Private Hospital, Camperdown – SSD-79888213 - Advice on EIS

The proposal seeks consent for a Concept application including a private hospital use with ancillary health and research, retail, commercial office and car parking. The reference scheme for the proposed building envelope includes three basement levels, a five-storey podium, and a 10-storey tower. No physical works are proposed as part of the Concept application.

Envelope Sections B & C - North
South

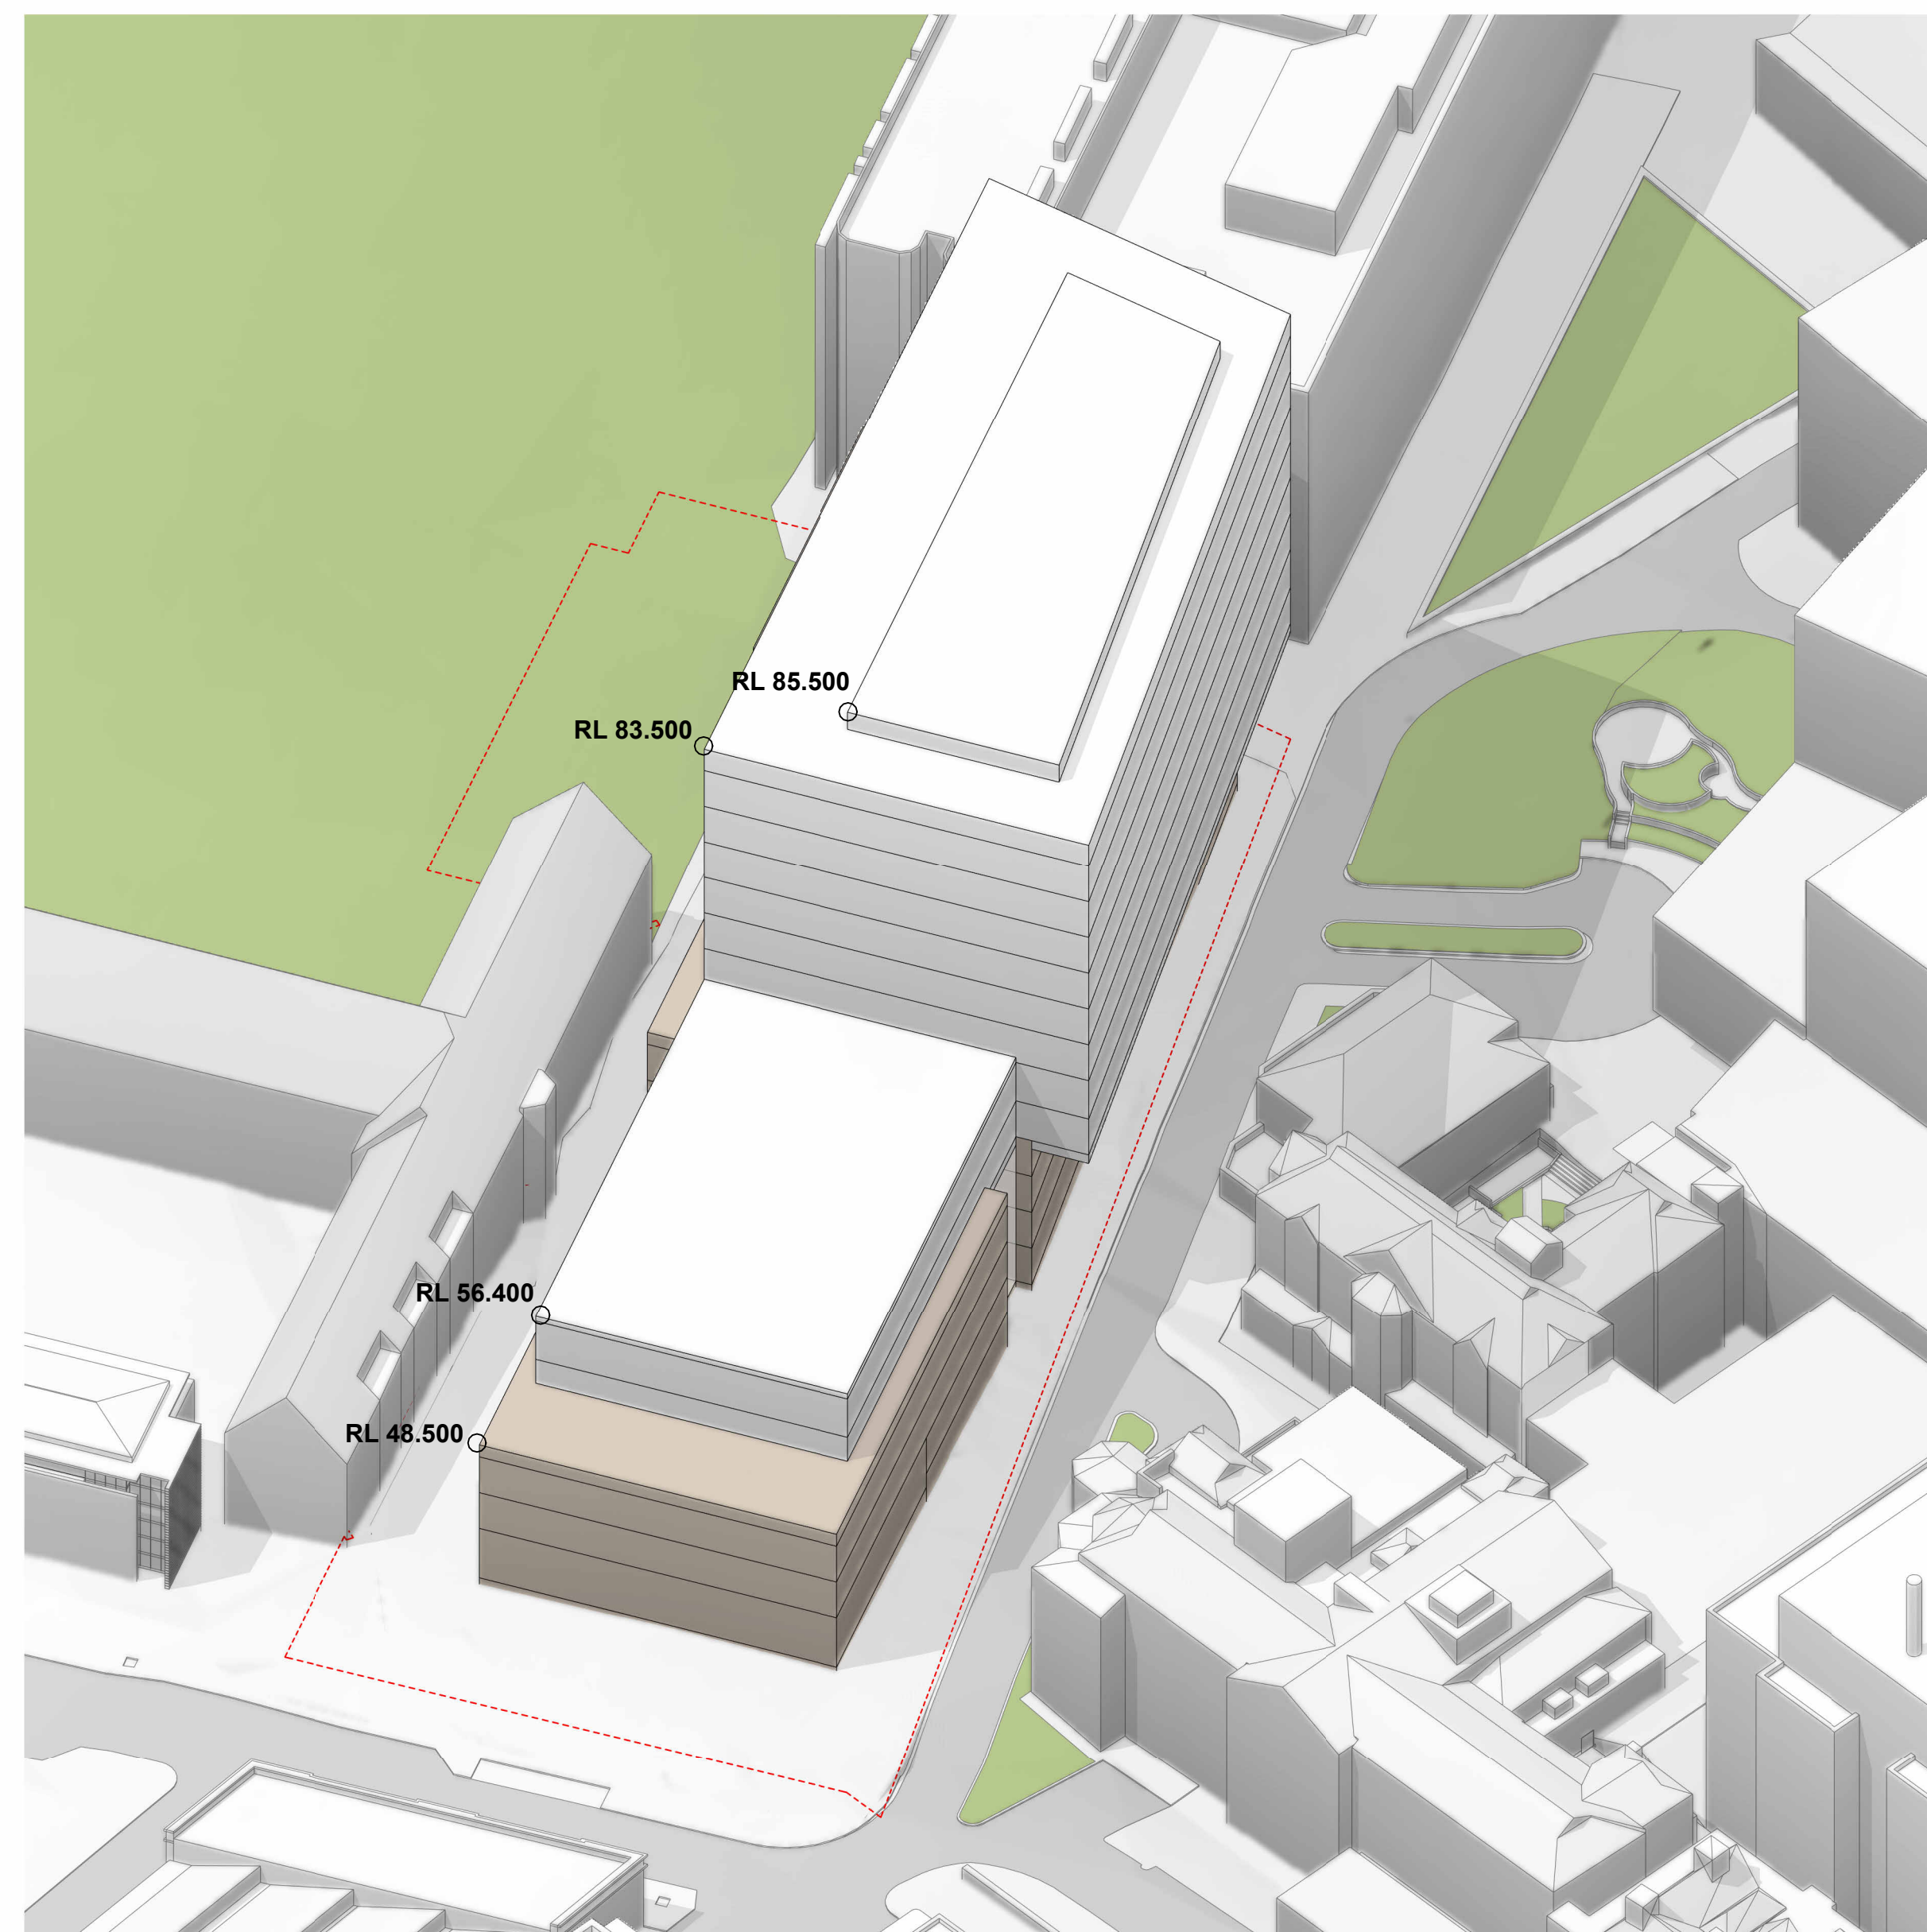
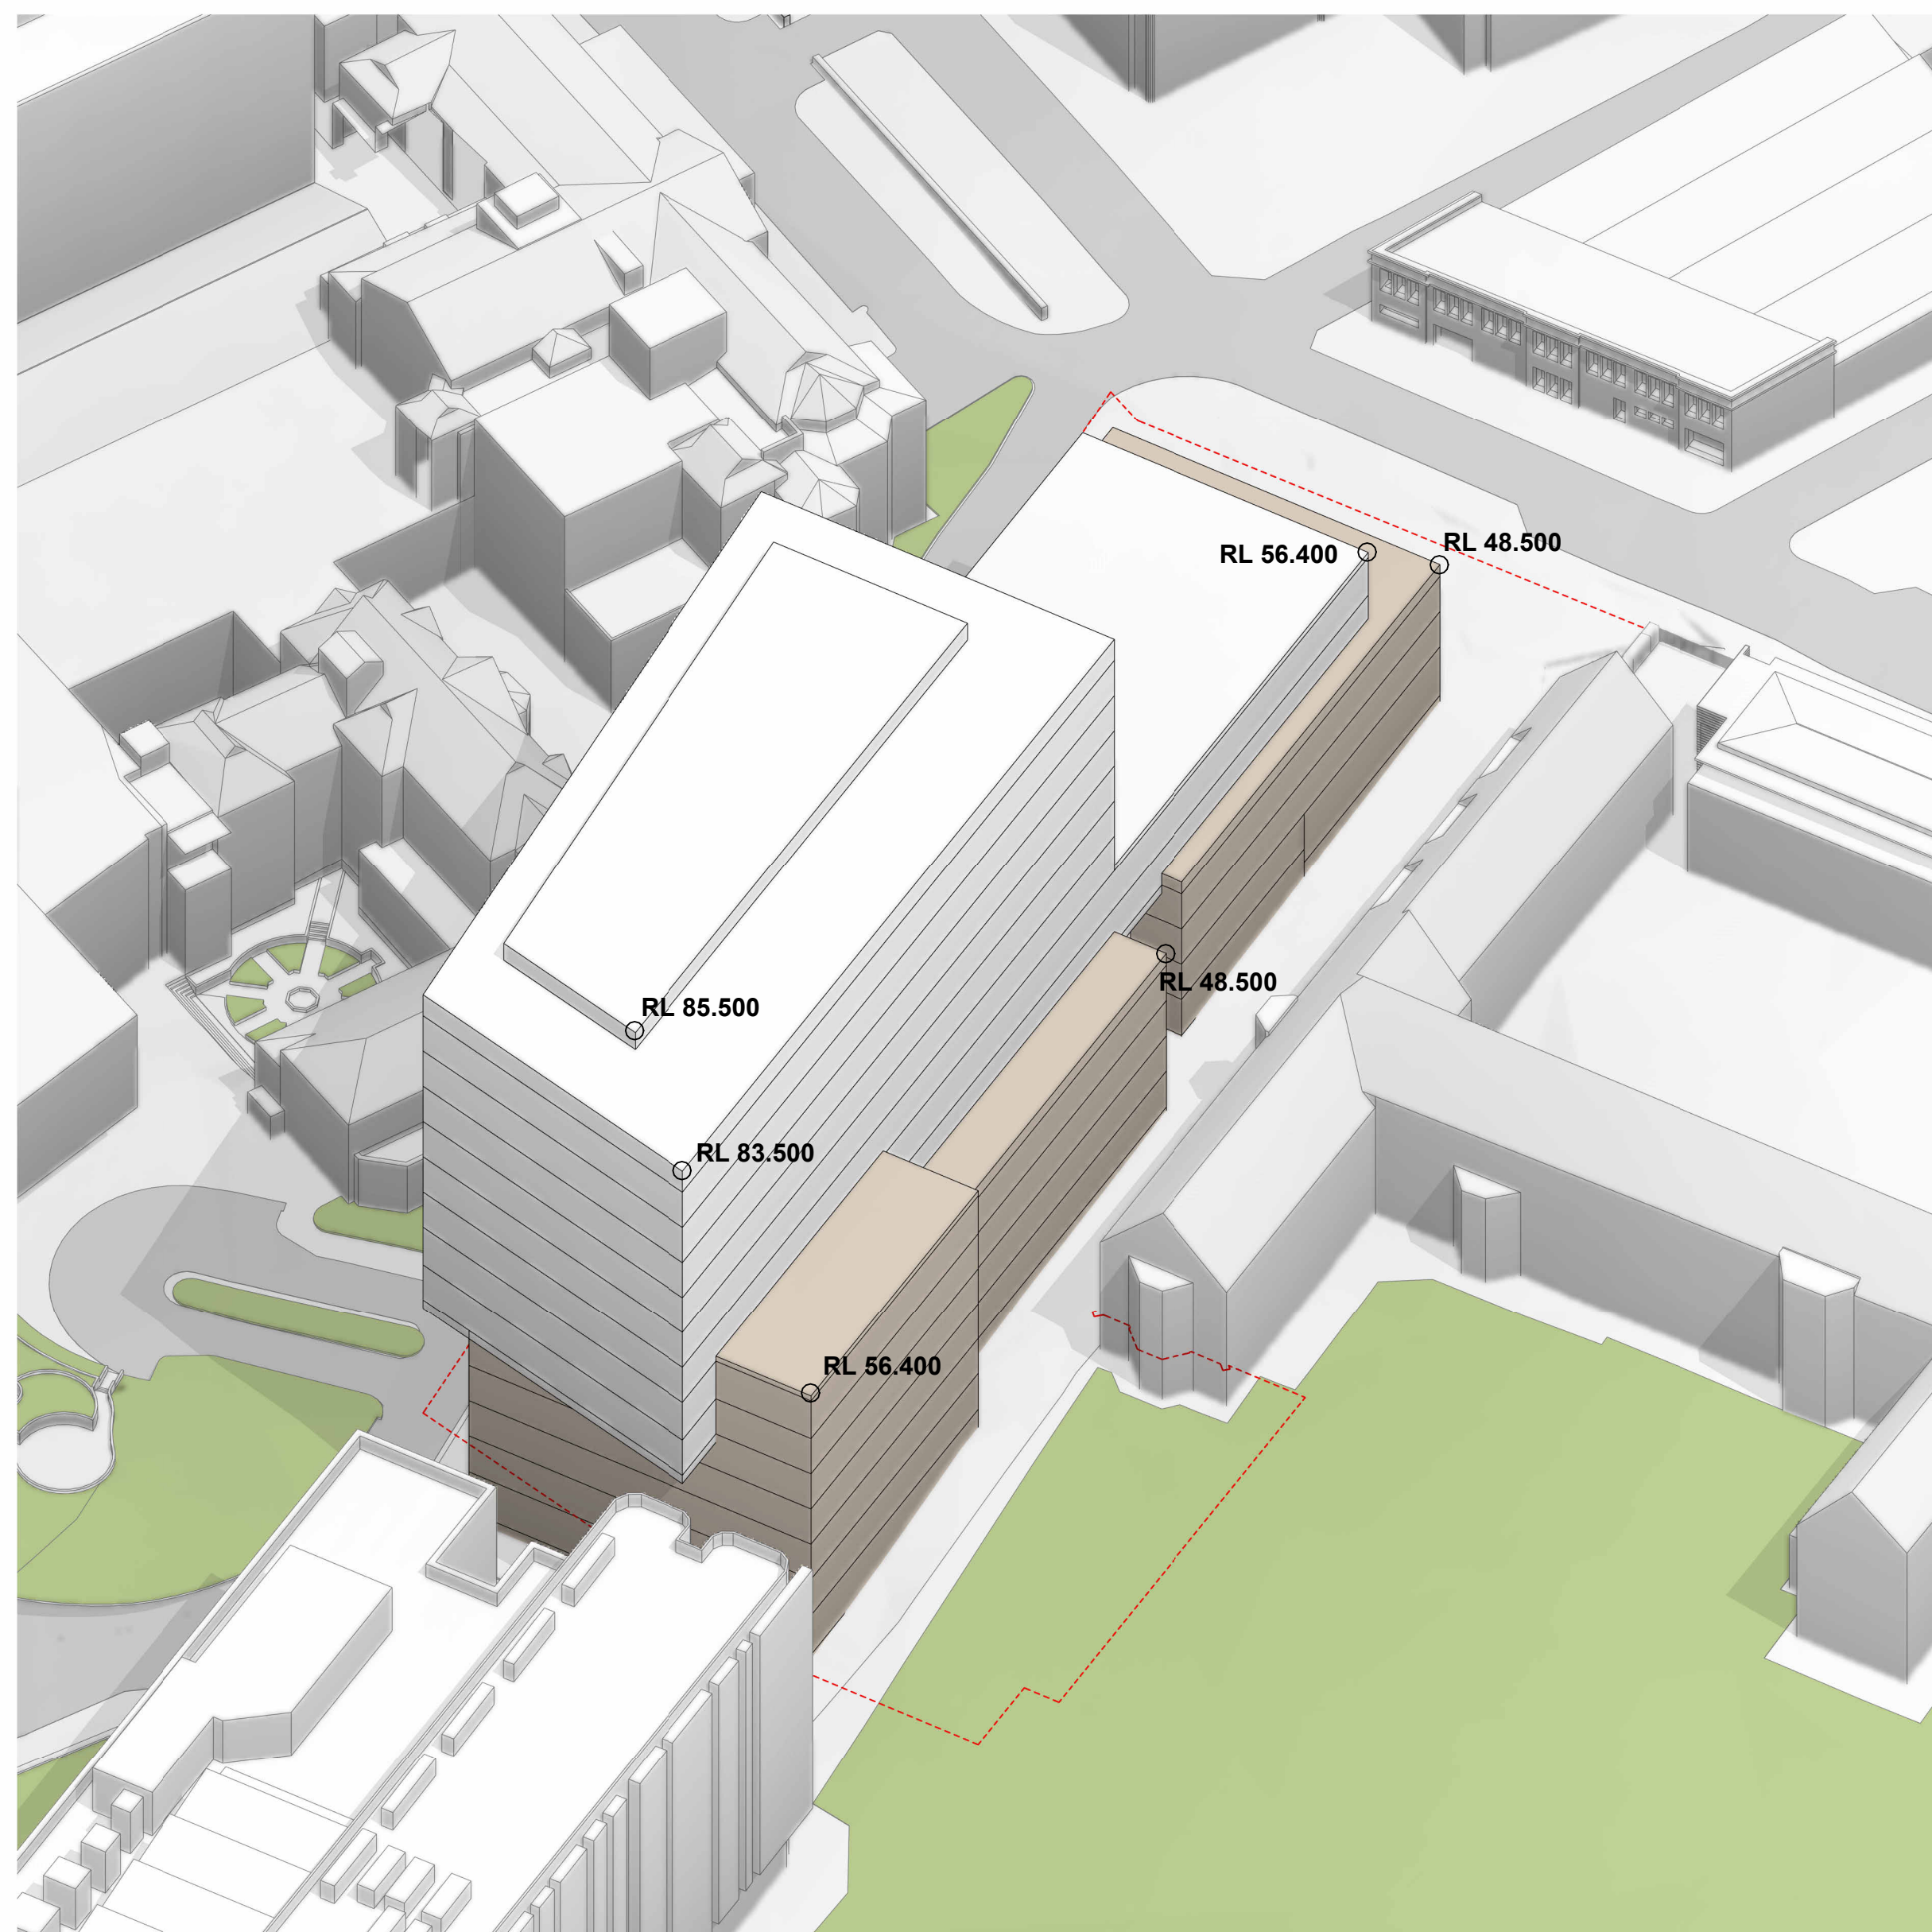
The proposed tower envelope, up to a height of RL 85.56 (57 metres), is significantly taller than most of the surrounding buildings within the hospital precinct. The tower element will be highly visible from the surrounding public roads, including the Missenden Road heritage street frontage and nearby open space areas, such as St John's Oval. The proposed height will have unacceptable impacts on the heritage significance of St John's College and continues to overshadow the nearby Royal Prince Alfred (RPA) hospital and its public spaces.

The City recommends that the tower element is reduced in height commensurate with the height of the Charles Perkins Centre (RL 58.5), as recommended by the SDRP

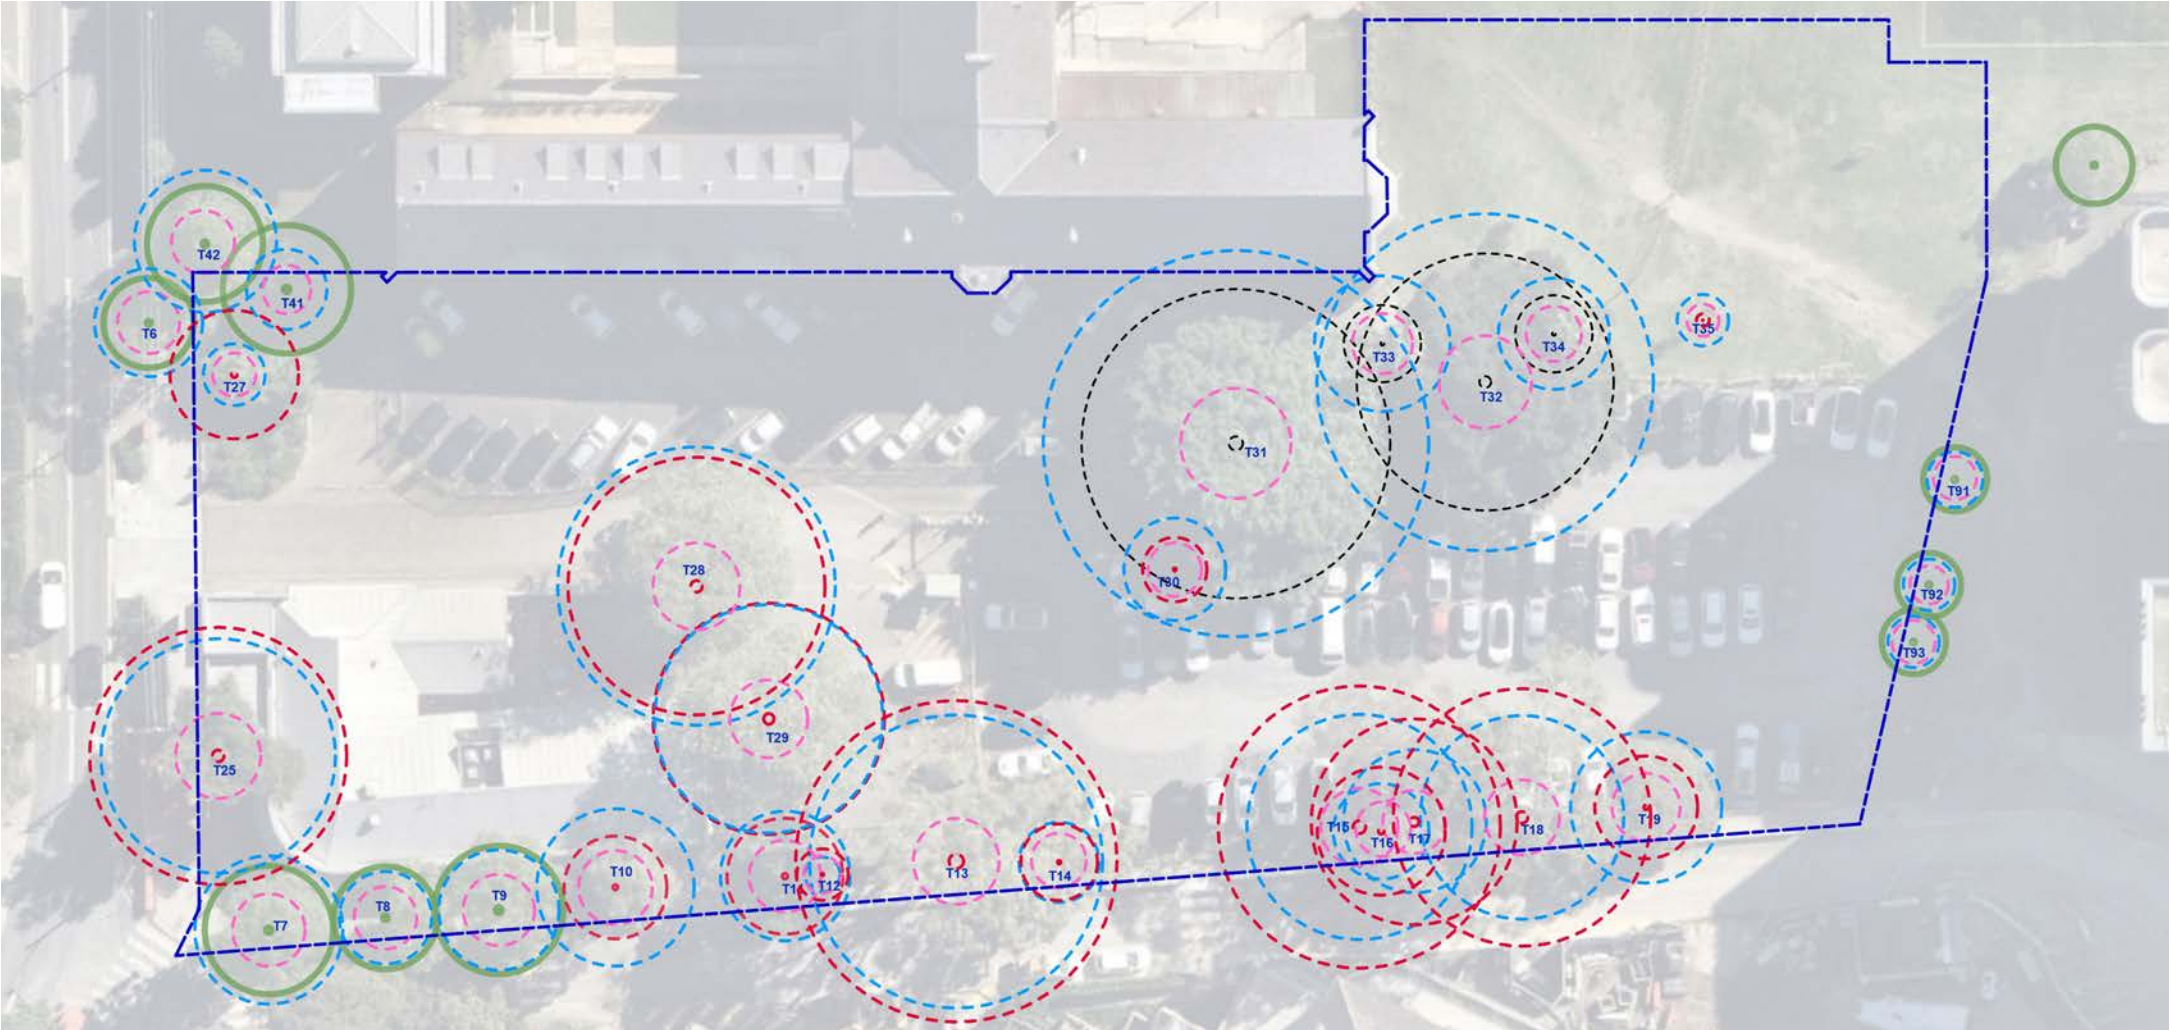
The proposed relocation of the high retention mature Fig trees (trees 31 and 32) to the north-eastern boundary of the Concept development area is not currently supported. The Transplant Feasibility Assessment is considered inadequate, and the proposed relocation site will negatively impact the heritage curtilage of St John's College as discussed further below.

The proposed location of Trees 31 and 32 in front of the eastern elevation of the Menzies Wing is out of character with the setting of the college and will intrude upon its principal elevation, which faces the playing fields. The proposed locations will disrupt view 4c and view 4d which are identified within the St John's College Conservation Management Plan (CMP) as being significant views of the College. The proposed location of Tree 32 will also block a significant view of the tower of St John's against the sky identified in the CMP.

It is therefore recommended that the Concept envelope is modified around the canopy zone of the trees to retain Tree 31 and 32 in situ. These trees would assist in mitigating privacy issues with St John's college while having therapeutic benefits for patients.
